Re: Rocglen Coal Extension Project (10_0015) EA Review

Thank you for the opportunity to comment on and review the Environmental Assessment (EA) for the Rocglen Coal Extension Project.

Pre-mining and post-mining agricultural suitability is shown on **Figure 10**.

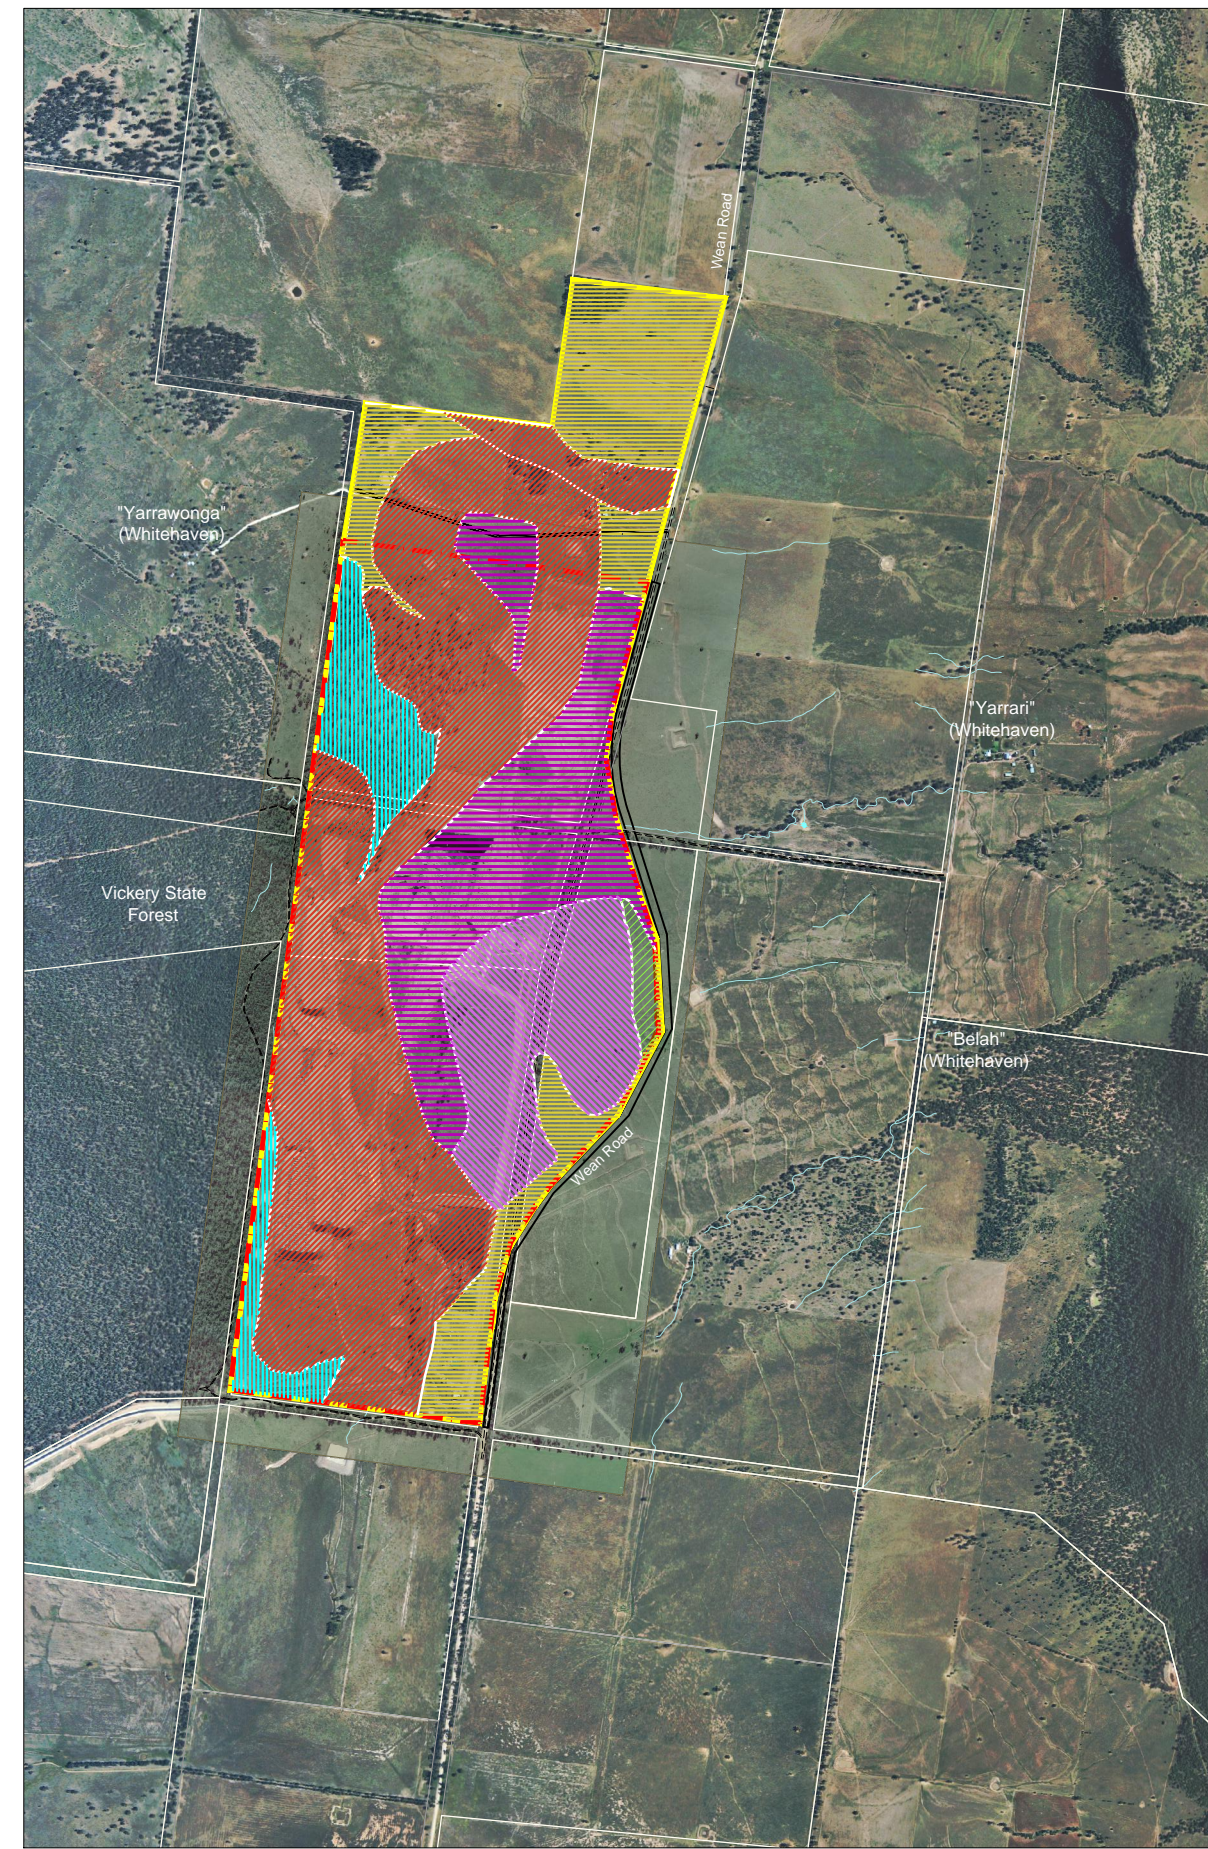
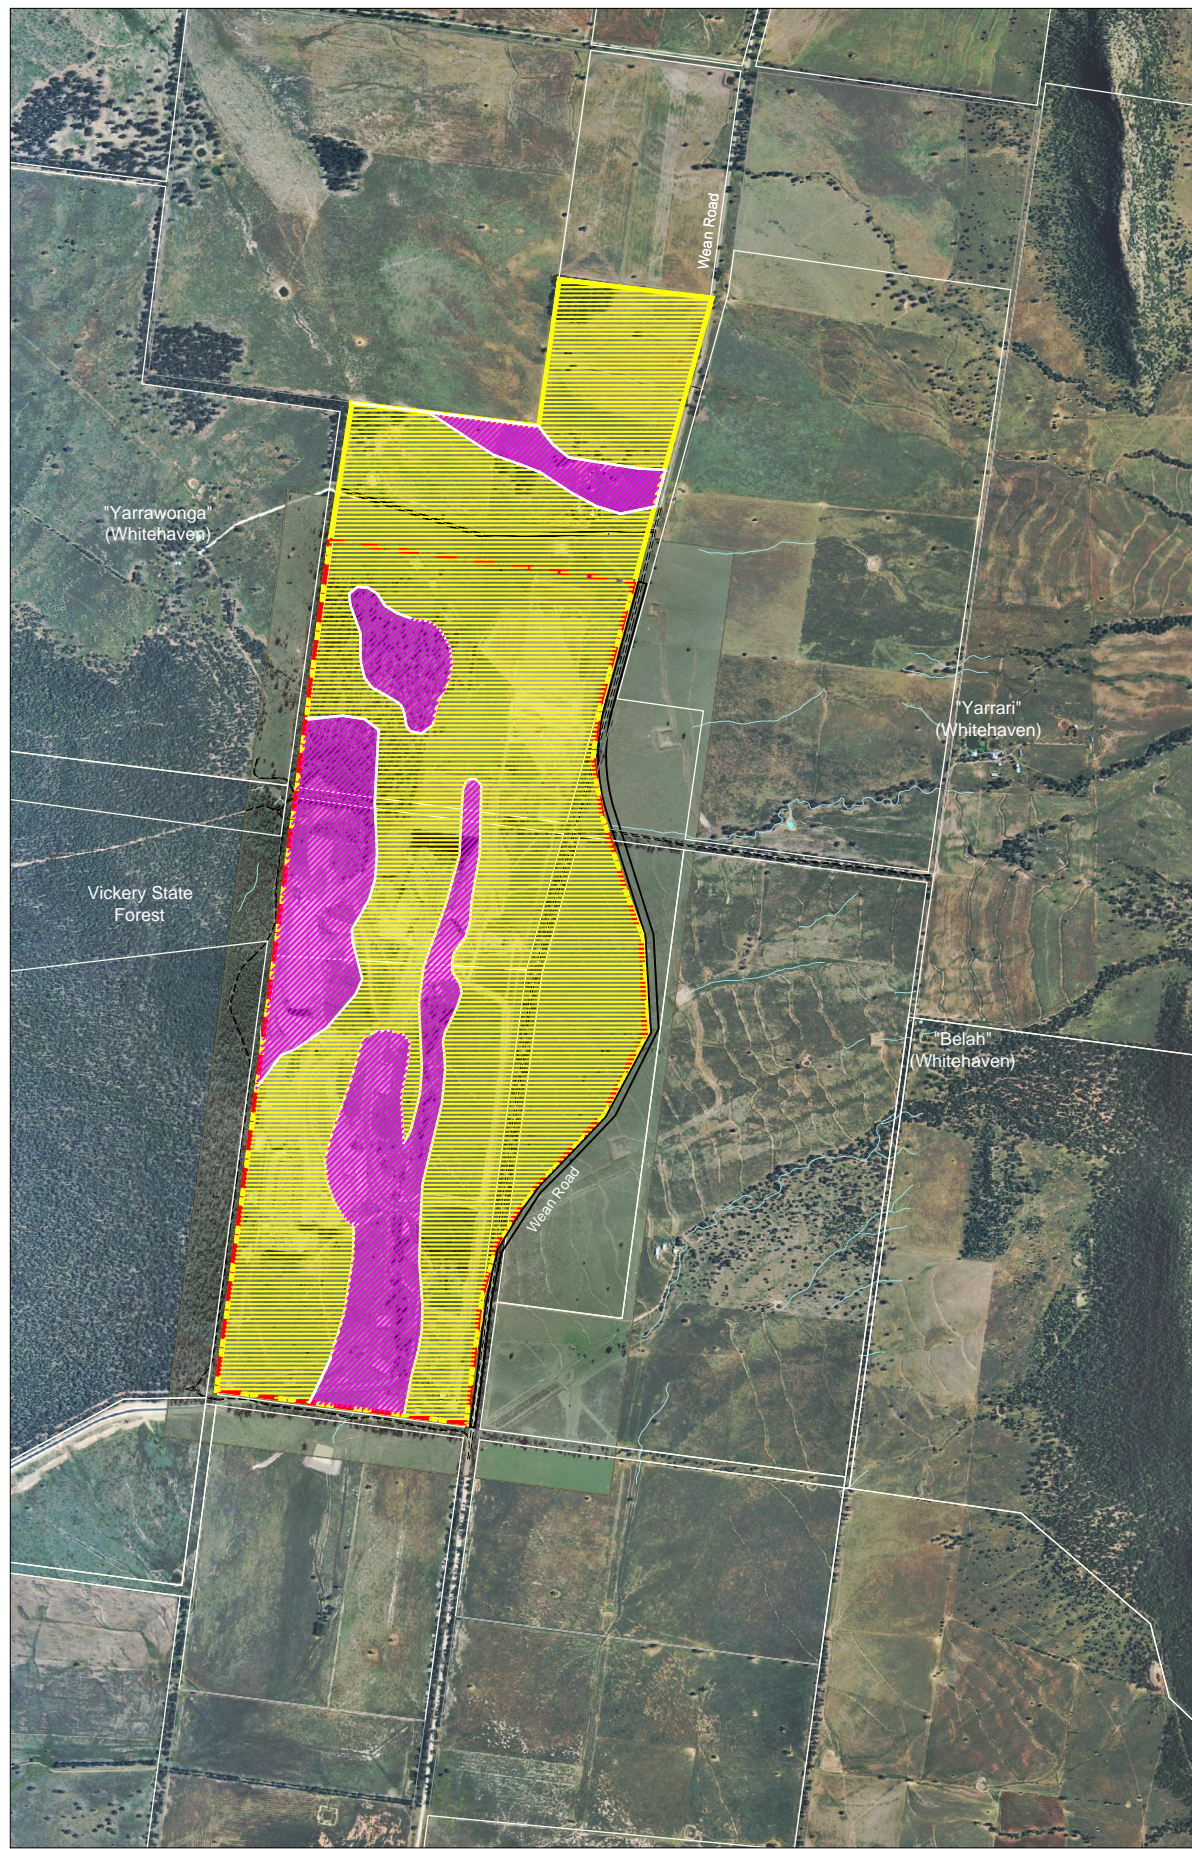
Similar to the logic applied for the Land Capability Assessment comments, the same logic can be applied to the Agricultural Suitability Assessment. For example, with a lower slope and shallower void the post mining suitability would be Class IV with no Class V.

Figure 1: Conceptual Rehabilitation Plan (note that configuration of the final void must be consistent with the Rehabilitation Management Plan)

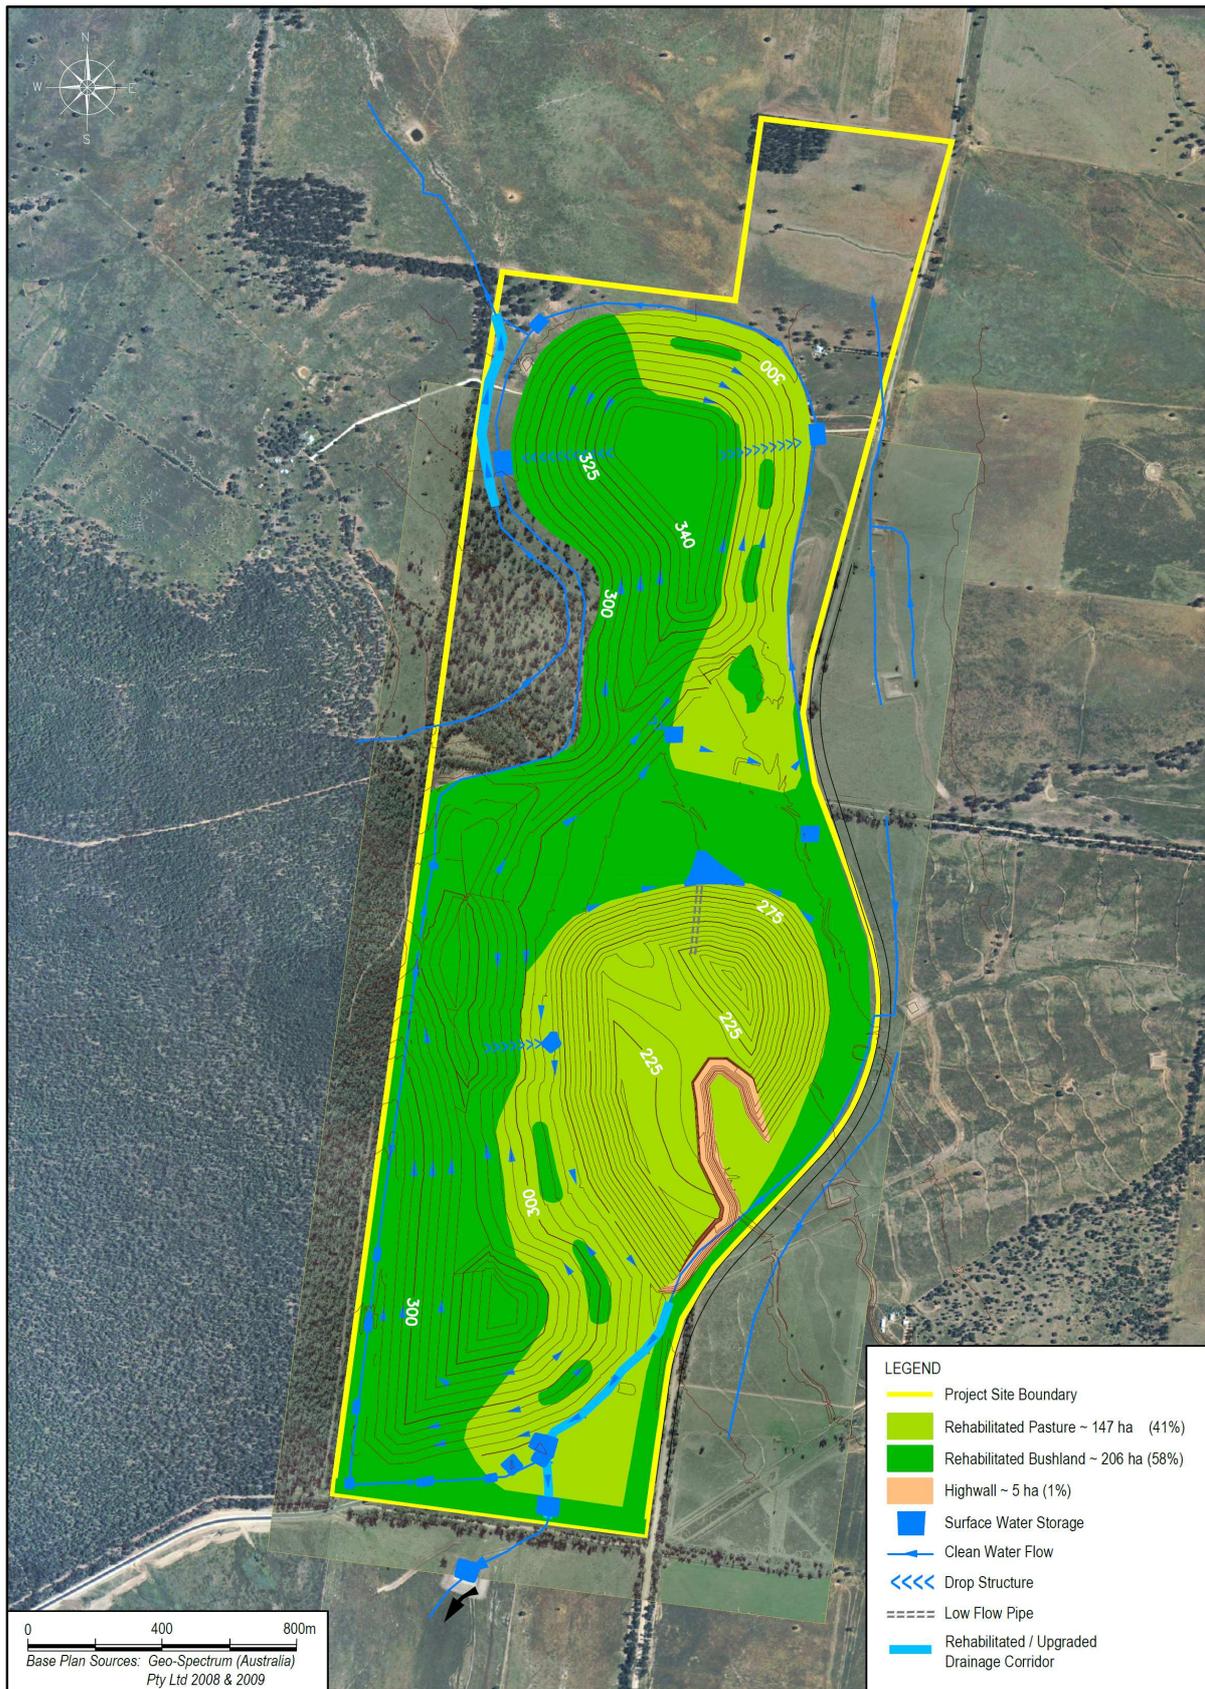
Namoi CMA is concerned that there will be a significant final void (65ha -18% of the anticipated disturbance area) left once mining is complete. The void will have batters ranging from 10° to 45° (18% to 100%) slopes. Furthermore, it is stated in the EA that the void will be around 65m deeper (AHD 220m) than the natural surface. This figure appears to be different to that provided in Figure 21 which indicates the void could be 85m deep (AHD 205m).

As stated in the EA, 58% anticipated disturbance area will be returned to rehabilitated bushland, which as depicted in Figure 21 will stretch around the northern reaches of the final void area and towards Wean Road. Namoi CMA would like to see a defined link between this rehabilitated bushland and the Whitehaven Regional Biobanking Site. It appears from Figure 21 that this link will consist of a narrow road and riparian corridor. We recommend that a 400m wide corridor centred on the existing road corridor be established to ensure connection between Vickery State Forest (Vickery CCA) and Kelvin State Forest (Kelvin CCA) and the Whitehaven Regional Biobanking Site. This 400m wide corridor would potentially add significantly to Whitehaven's Biodiversity Offset Strategy especially if the area was revegetated to White Box Grassy Woodland.

Figure 21 in the EA currently indicates that the final void area (65ha) would be returned to 'Rehabilitated Pasture'. However, as this area has been currently assessed in the EA as being Class VII and Class VIII post mining then the recommended landuse for Class VII land is 'green timber' while the Class VIII lands

should not be grazed. These land capability classes and land uses are converse to the proposed landuse of 'Rehabilitated Pasture'.

- that the void be minimised in area as much as possible.
- that the final batters on all slopes be no greater than 10° (18%).
- that the final void batters be topsoiled and rehabilitated to permanent pasture.
- that suitable soil conservation measures be installed within the void area to prevent soil erosion.
